# RESPONSE TO AN BORD PLEANÁLA OPINION

**PROPOSED STRATEGIC HOUSING DEVELOPMENT ON LANDS AT THE  
FORMER GREENPARK RACECOURSE, DOCK ROAD, LIMERICK**

**VOYAGE PROPERTY LIMITED**

**October 2021**

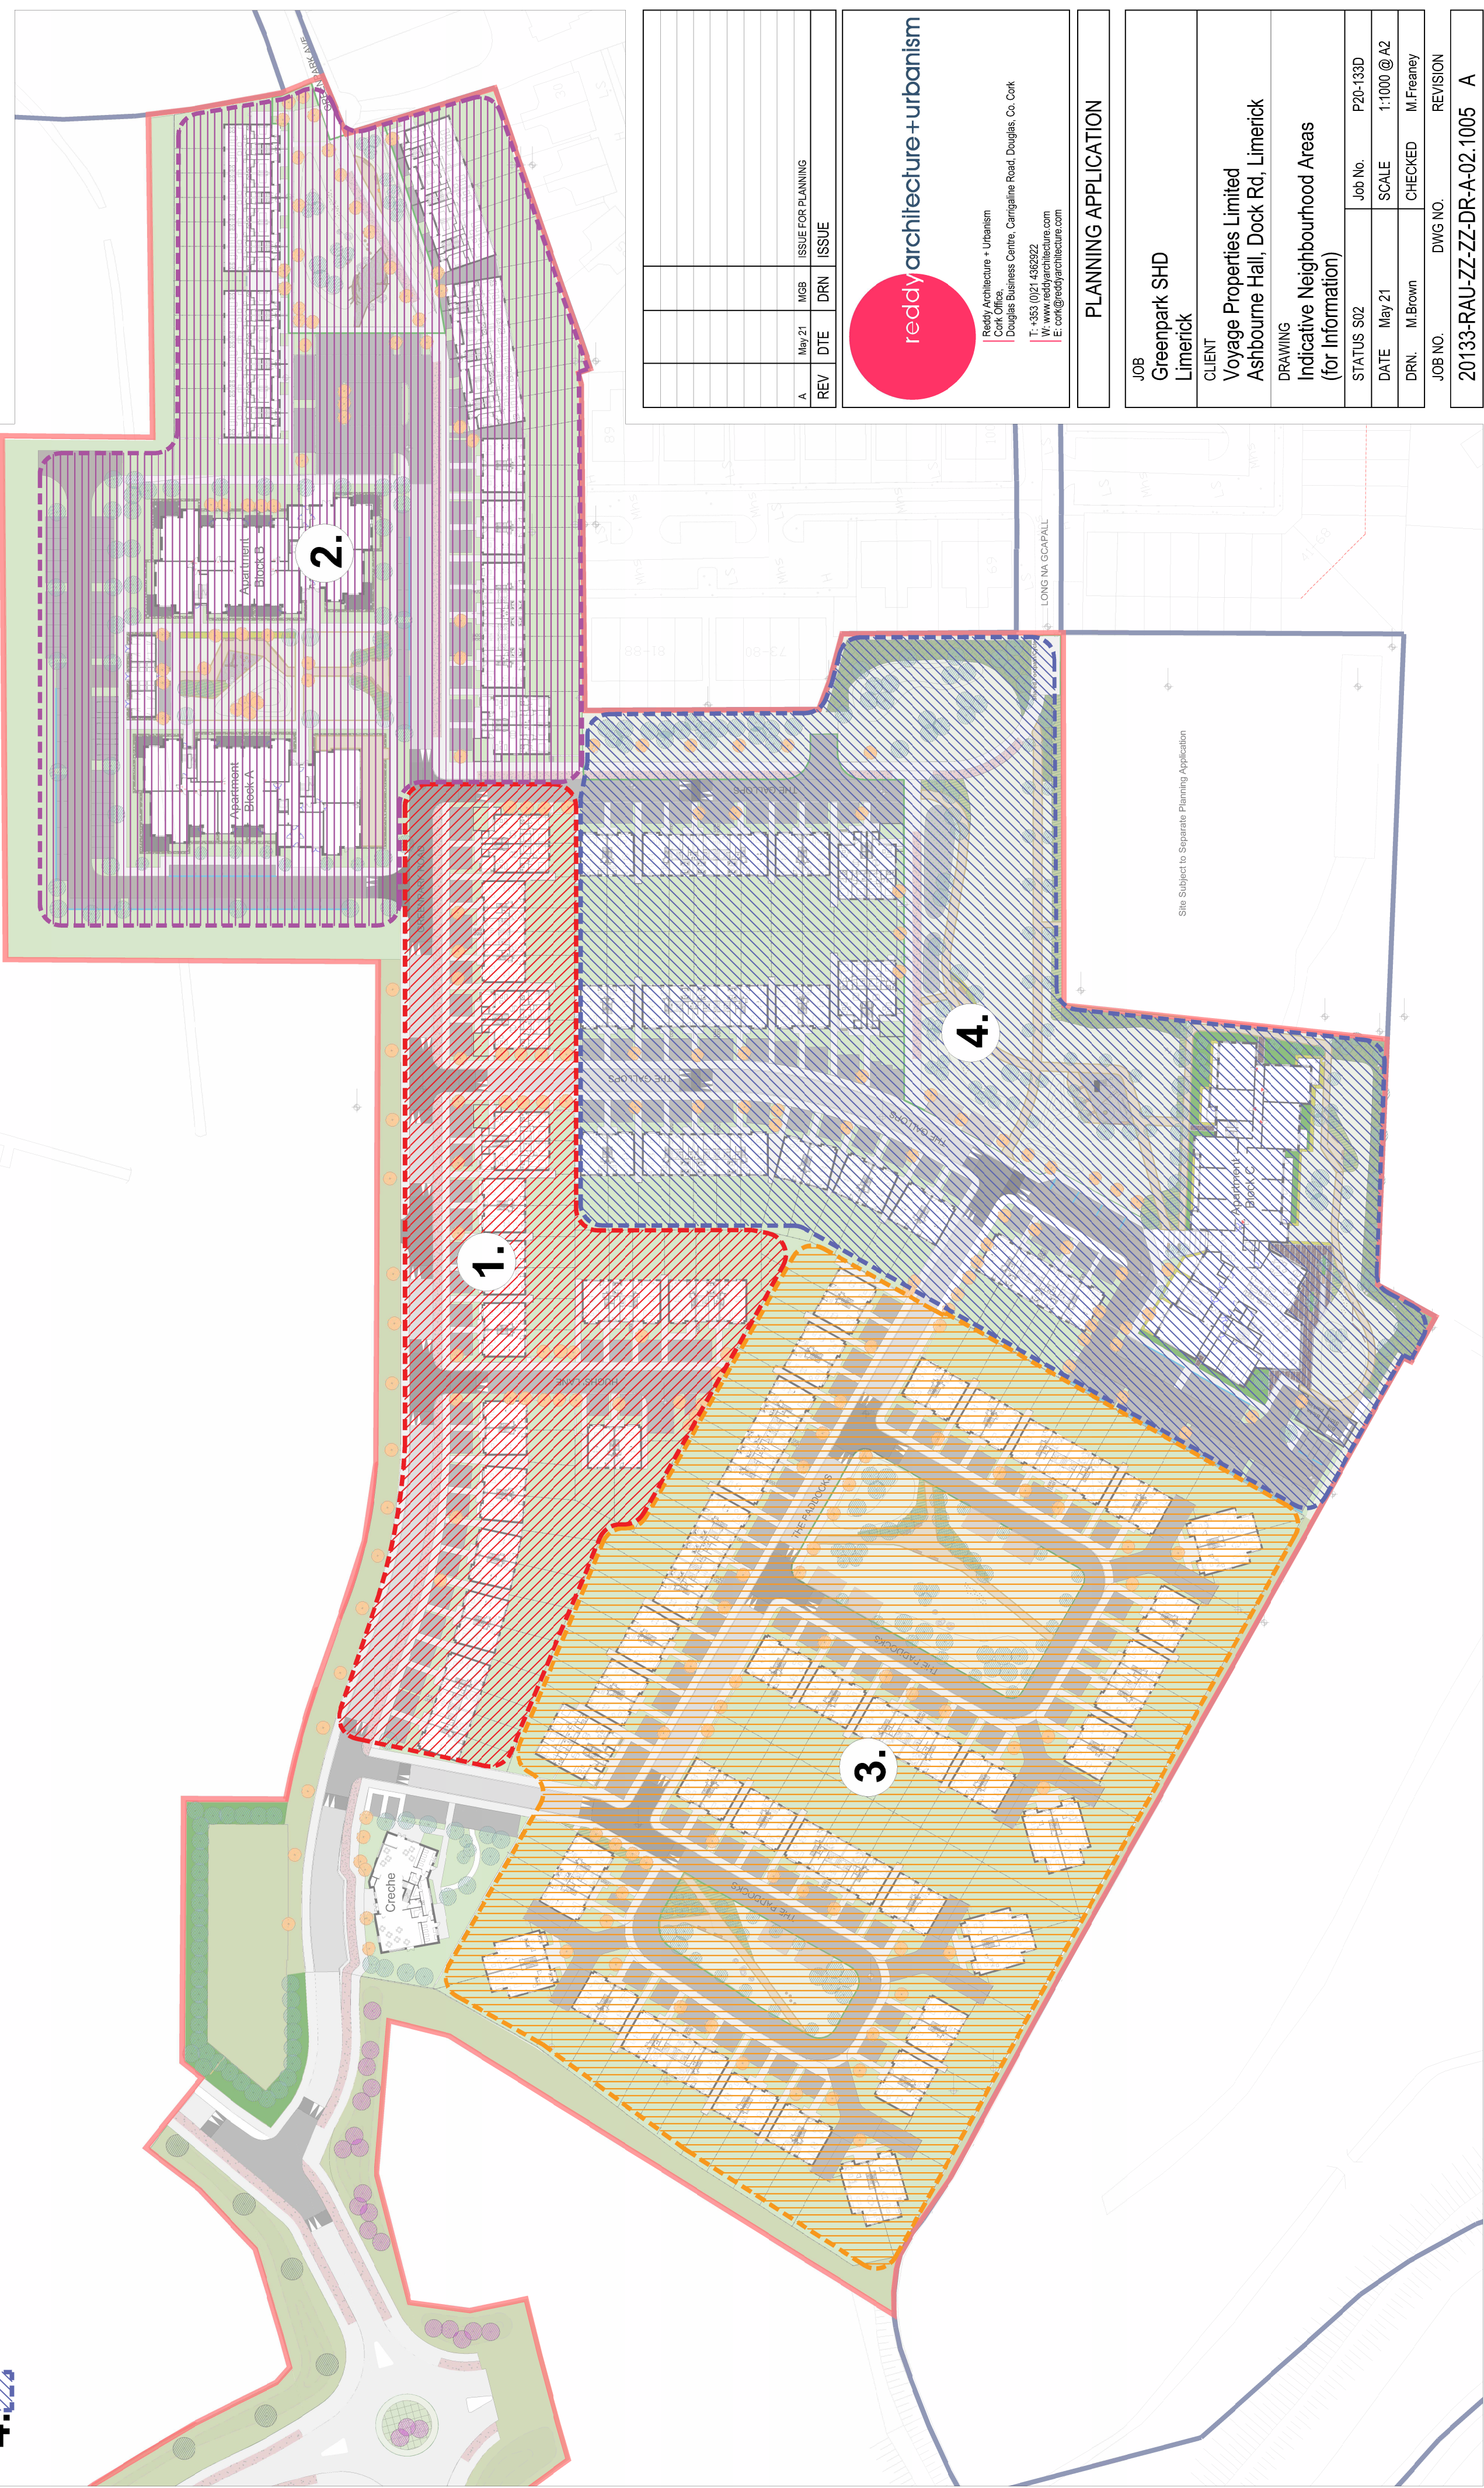
*The development shall comprise separate Character Areas, with an integrated hierarchy of public open spaces at accessible, well overlooked locations throughout the site. The public open spaces shall address specific functions such as active / passive open spaces and play areas. The Character Areas shall include a consistent approach to (i) the design and finish of houses / apartment buildings; (ii) roads and footpaths layout materials and finishes; (iii) hard and soft landscaping and tree retention (where proposed); (iv) biodiversity enhancement measures; (v) relevant SuDS measures.*

The proposed SHD scheme has been broken down into series of Character Areas/ Neighbourhood Areas. This is shown on Reddy Architecture + Urbanism's Dwg. No. 20133-RAU-ZZ-ZZ-DR-A-02.1005 Rev A and pages 37-40 of the enclosed *Design Report* which sets out the design rationale for each character area. These include:

- Neighbourhood/ Character Area 1: Greenpark Road
- Neighbourhood/ Character Area 2: Greenpark Road Upper
- Neighbourhood/ Character Area 3: The Paddocks
- Neighbourhood/ Character Area 4: The Gallops
